**From:** [REDACTED]  
**Sent:** 09 October 2025 12:08  
**To:** Planning <[Planning@arun.gov.uk](mailto:Planning@arun.gov.uk)>  
**Subject:** FP/134/25/HH

Objection comments on the above application.

Terry Phillips, Eaves, Old Coastguards.  
Bognor Regis.

Project: The Watch House
Old Coastguards
Felpham
PO22 7BJ
Client: Mrs Mountain
Drawing Title: Proposed Elevations & Upper Floor Plans

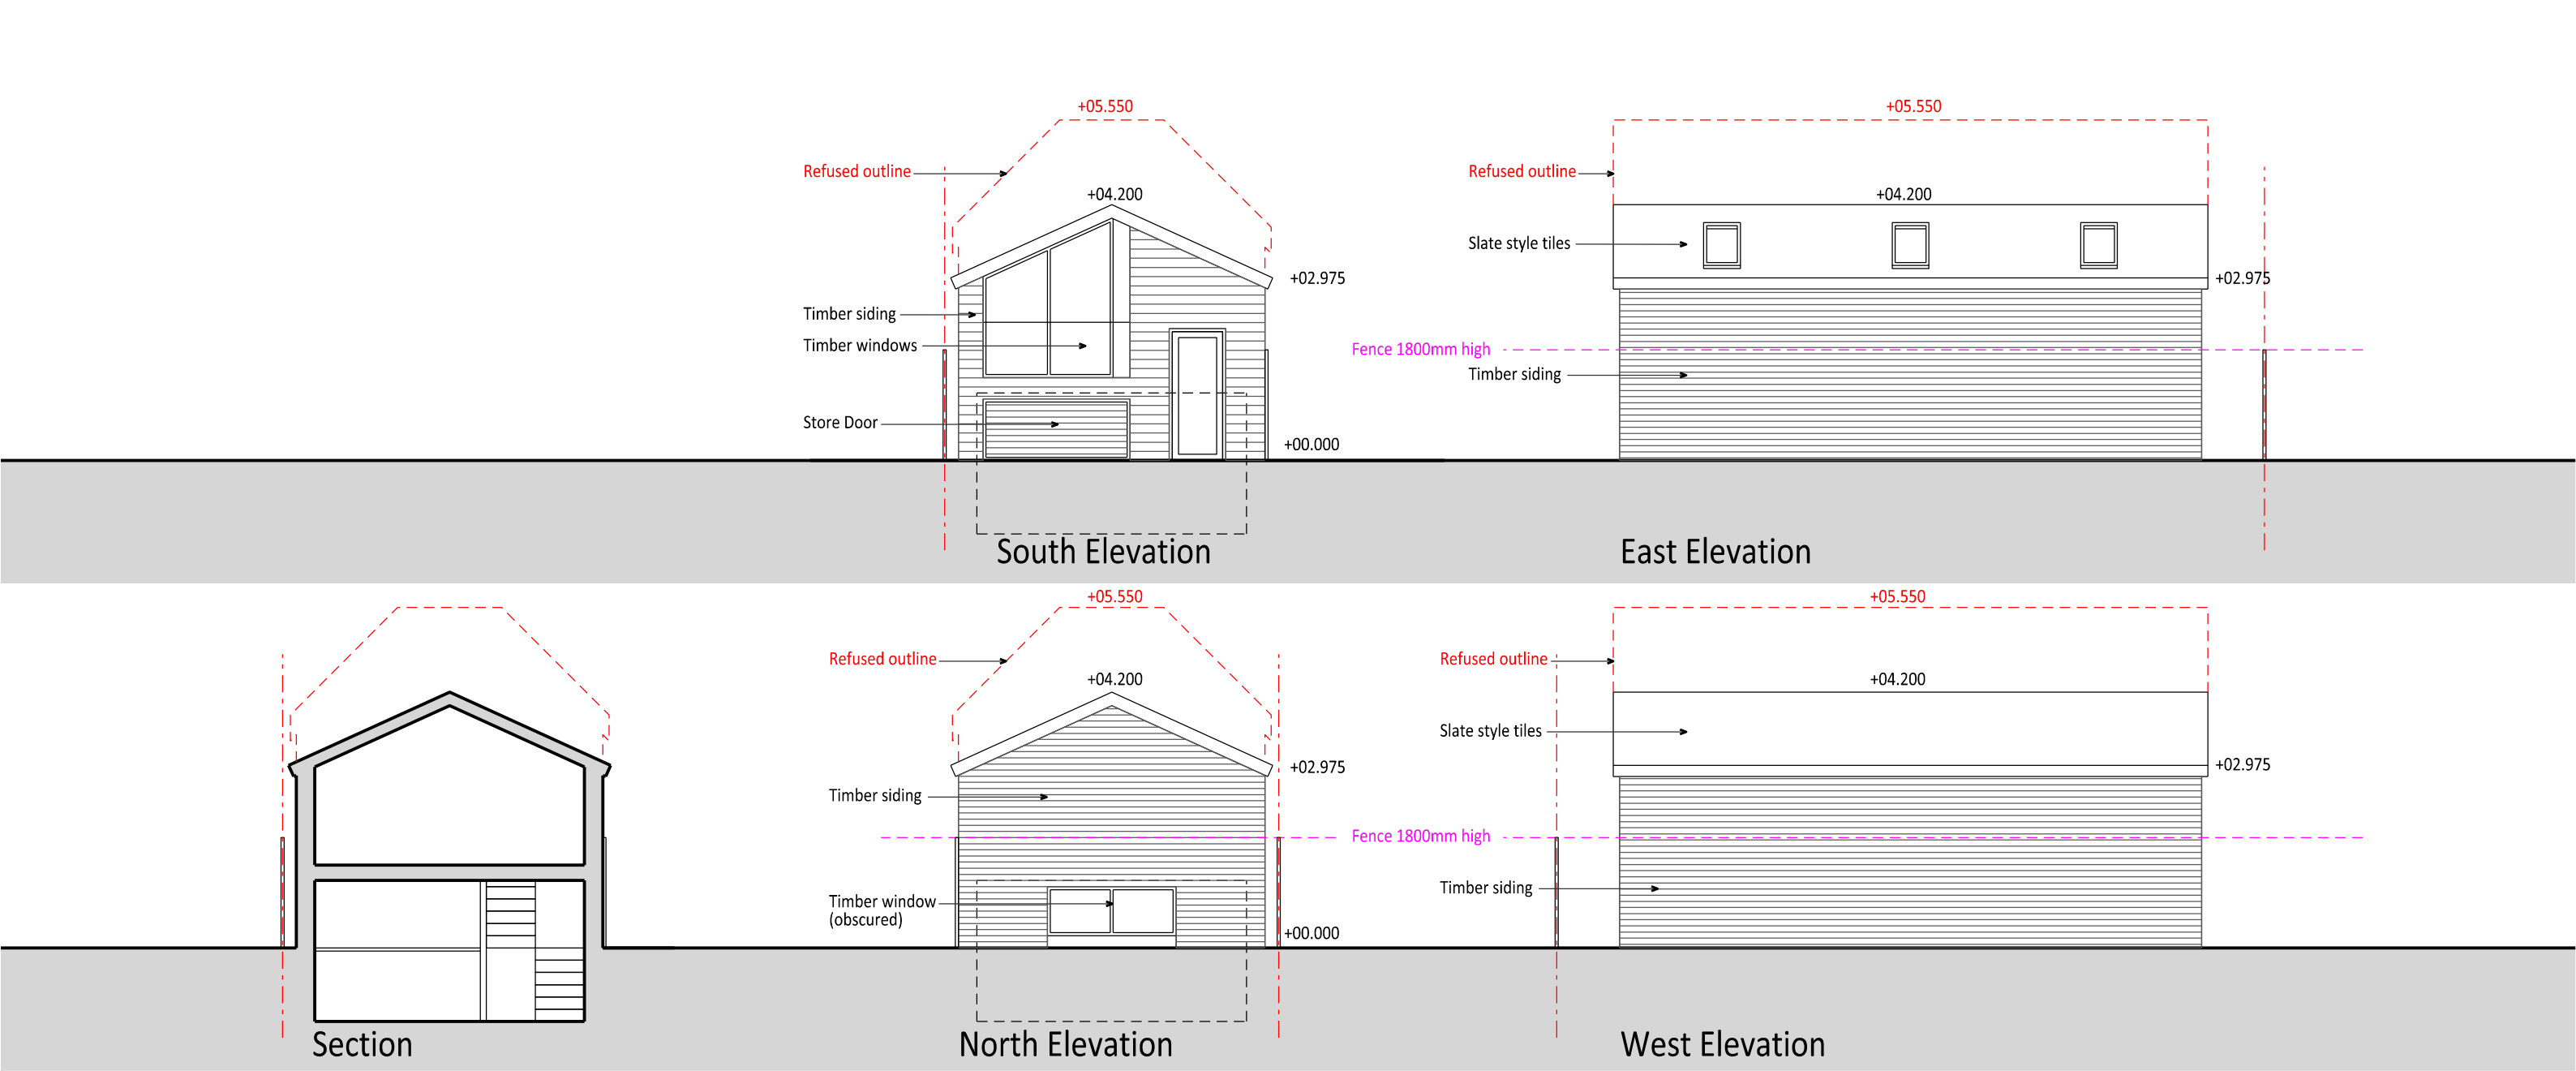
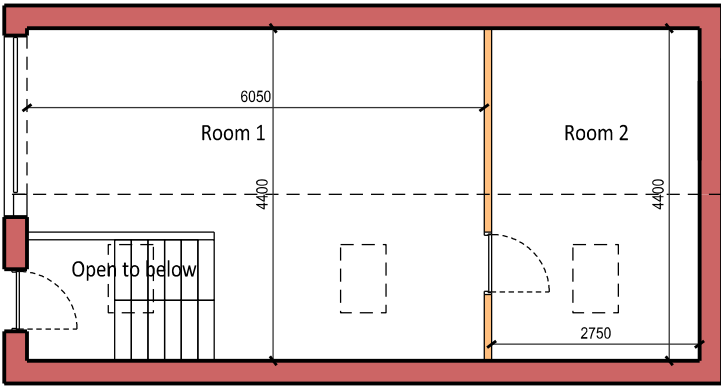
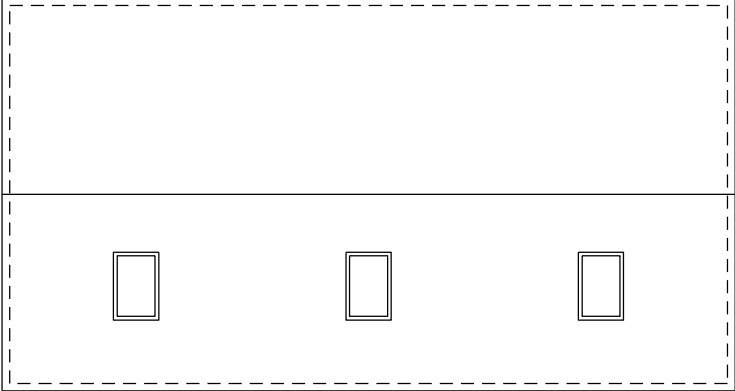
Dealing with the light issue, the roof line has been reduced by 1.35 metres, from 5.55 metres to 4.2metres. This in itself still reduces the light into my conservatory and lounge as I'm still looking at a 13 feet wall some 5ft from my conservatory window. Not only blocking light but also any view that I might have.

To accommodate this reduction in roof height the new plans show the building being sunken into the plot by possibly the same amount as the roof height reduction.

To accommodate this reduction in my experience soil will have to be removed from the plot to a greater depth to accommodate the formation of floors and walls and for support of the subterranean floor. It is unspecified as to what depth the digging will take, however if the depth is anywhere near 1.8 or 2 metres then this presents a serious and dangerous problem. The new plans show that the rear corner of the proposed new building nearest to my house is only 1.4.metres away from the corner of my house.

If piling sheets are to be used then I vehemently reject the use of this method as this entails thumping or vibrating sheets to support the excavation and of course vibrating sheets into the ground within a possible 1.5 metres of my property. I fear that my 93 year old foundations will be destroyed. I'm also concerned about the weakening of my conservatory foundations.
